Castle Hill & Hills District Agricultural Society Inc.

APPLICATION NUMBER SSI-5414

Castle Hill & Hills District Agricultural Society Inc. North West Rail Link Environmental Impact Statement 2 – Submission

Figure 6.19 Showground Station - Indicative layout

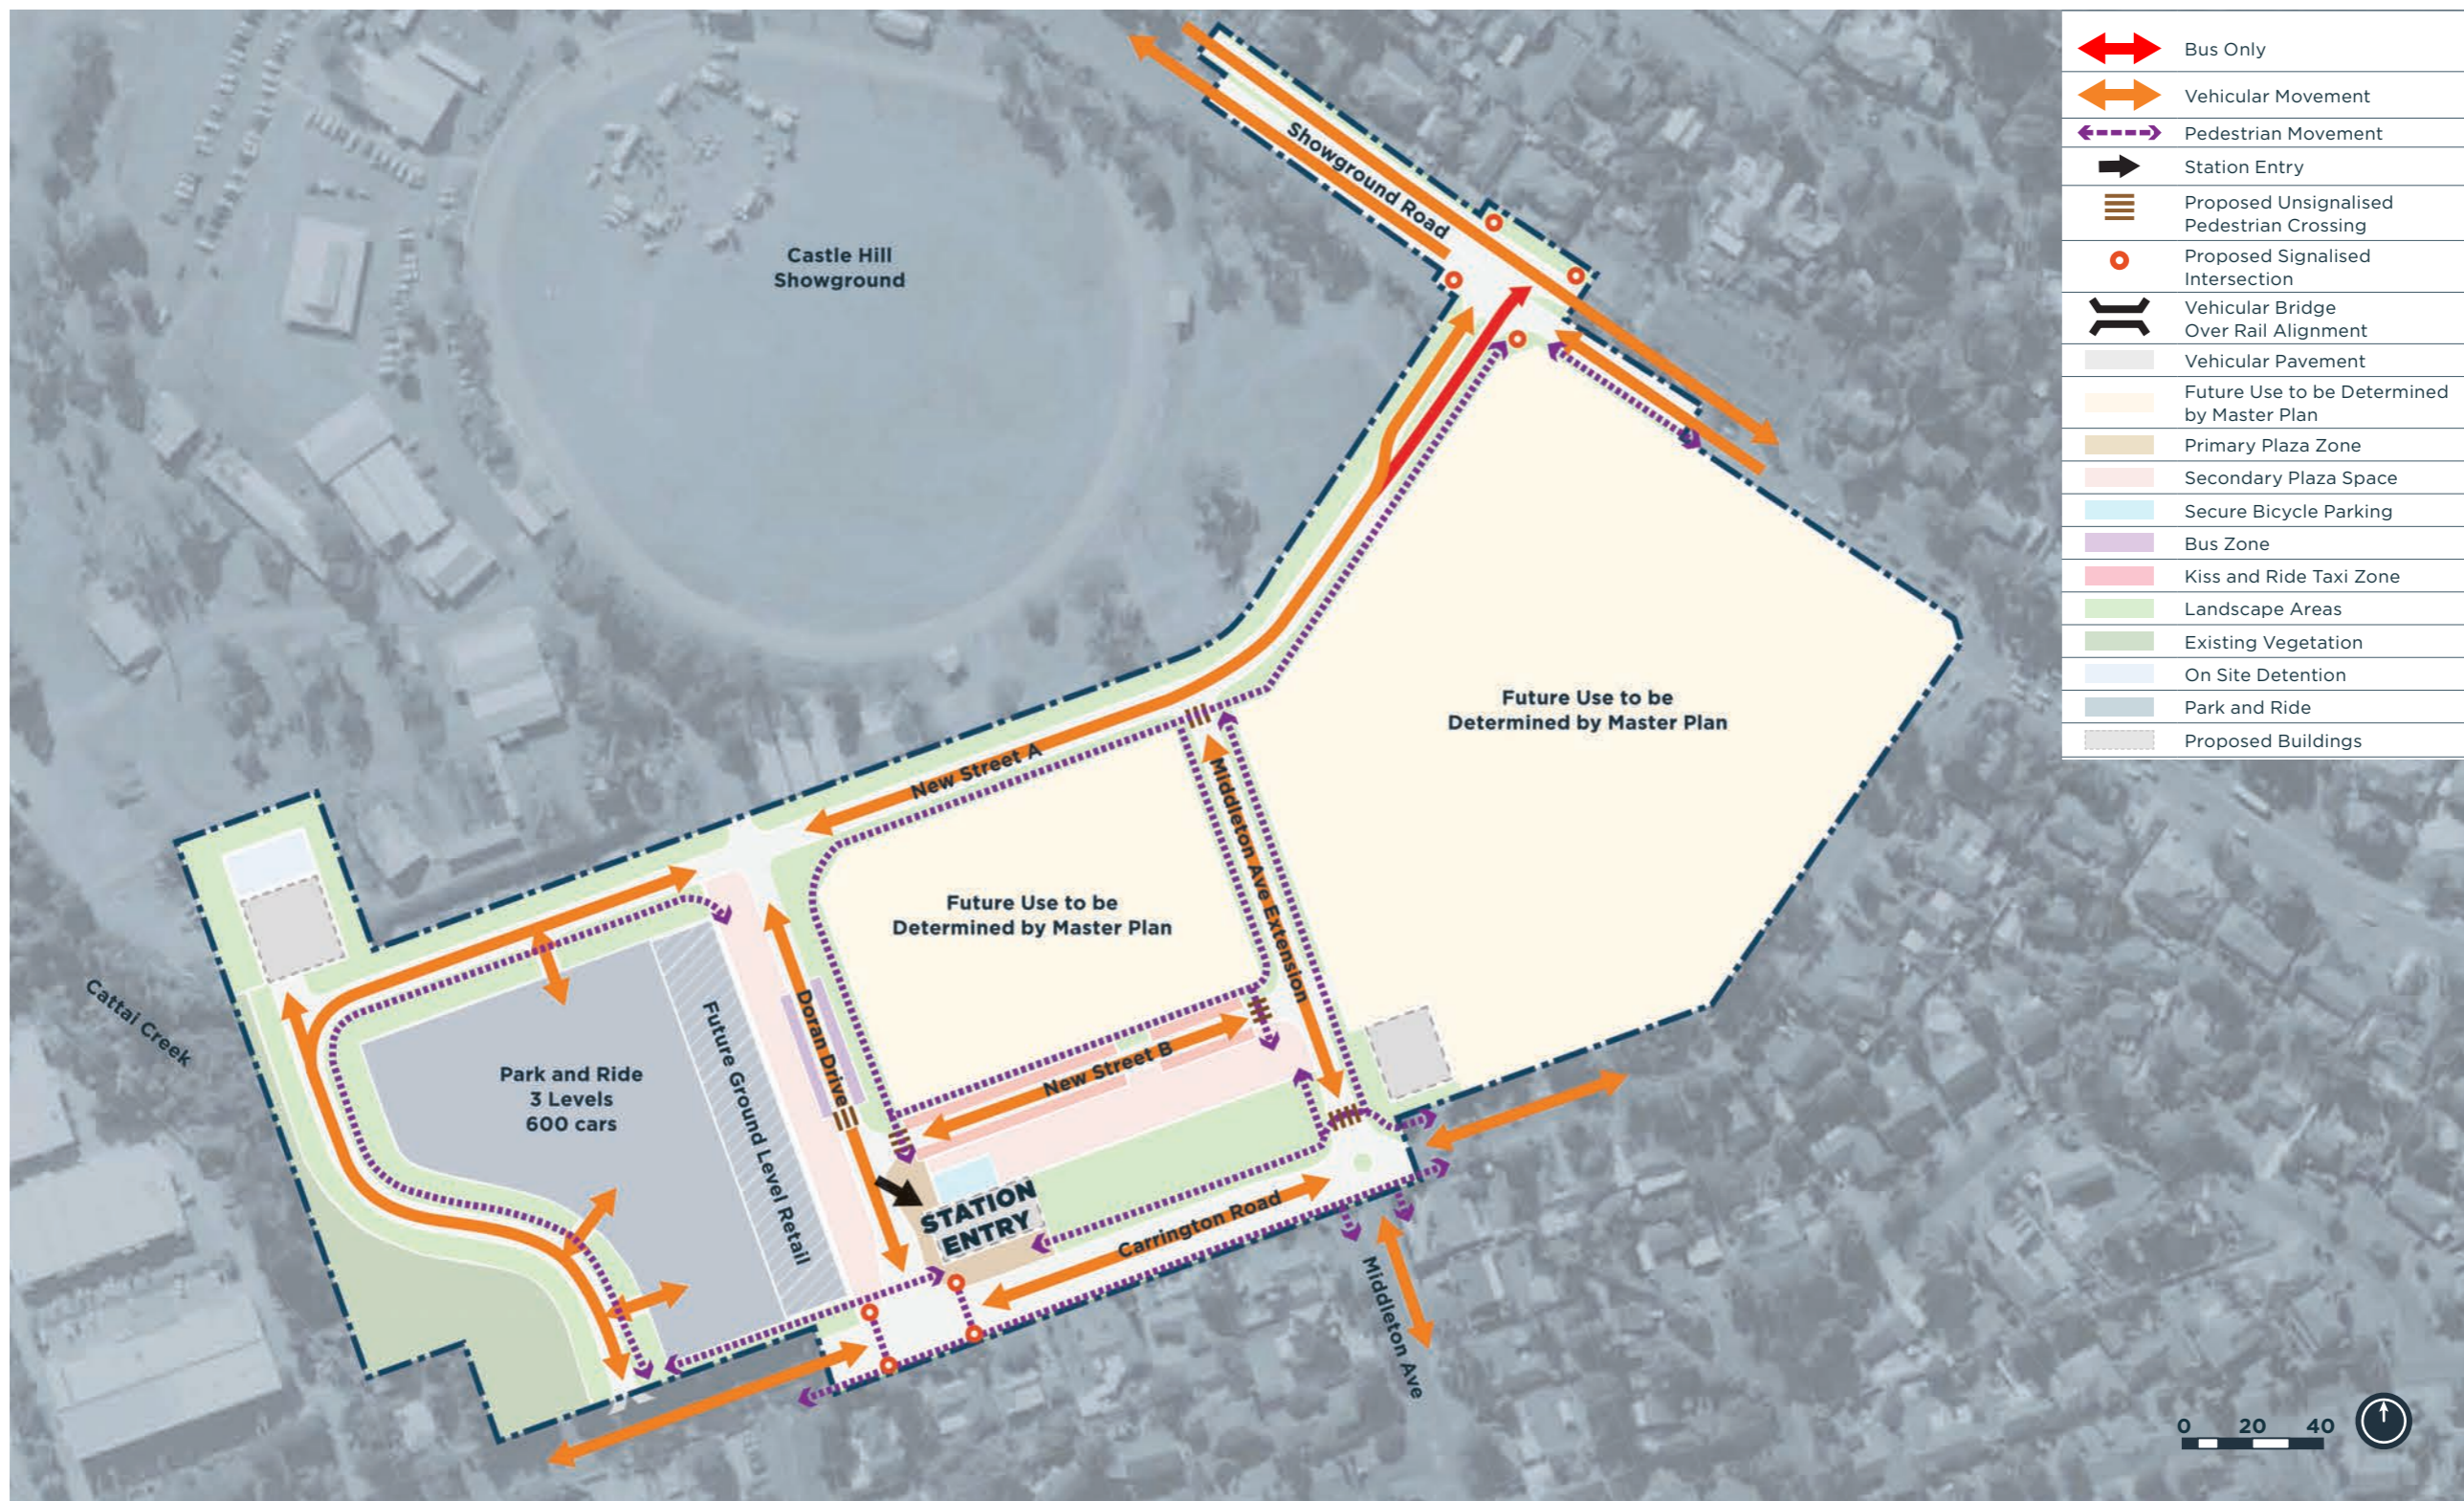
- The trotting stables, toilet block and horse measuring block (32) could be relocated within the horse area (green shaded area)
- The amenities block (15) could be relocated within the horse area (pink shaded area).

- The Danny Scott Stables (27) and The Milton Evans Stables (26) are not physically effected by the boundary shown in EIS 2. This boundary will need to be fenced, to provide security between the showground and the new street 'A'. This would then prevent access to the stables and require major modification and/or relocation

- The only vehicle entrance at showtime is via Doran Drive where there are two ticket kiosks. It operates as 'in' only with 3 lanes for traffic to queue. The relocation of the kiosks and queueing area whilst construction is undertaken and also following completion, requires further consideration and preparation of construction traffic management plans and further discussions.

- During the Show and for other major events on the Showground access is in Doran Drive off Carrington Road and egress left only onto Showground Road. A recent major event was the Wiggles Concert. This arrangement is still required at Showtime to retain a separate egress. This exit could be along the road between the Carpark and Cattai Creek suggested above for use during construction stage. The entrance could be along the haul road off Showground Road with restrictions on the use by construction traffic during these events.
- ***Access within Showground*** - The perimeter road around the showground is required for the show and other major events held on the showground. It is required to provide access for emergency services such as an ambulance, police and fire services. Currently shown in EIS2, this access will not be possible between the stables (buildings 26 & 27) and "New Street A".

- The proposed Showground boundary, along New Street 'A' (Haul Road) shown on the construction site plan (page 83) indicates additional impact on the horse parking area to that shown on the Showground Station layout (page 33).
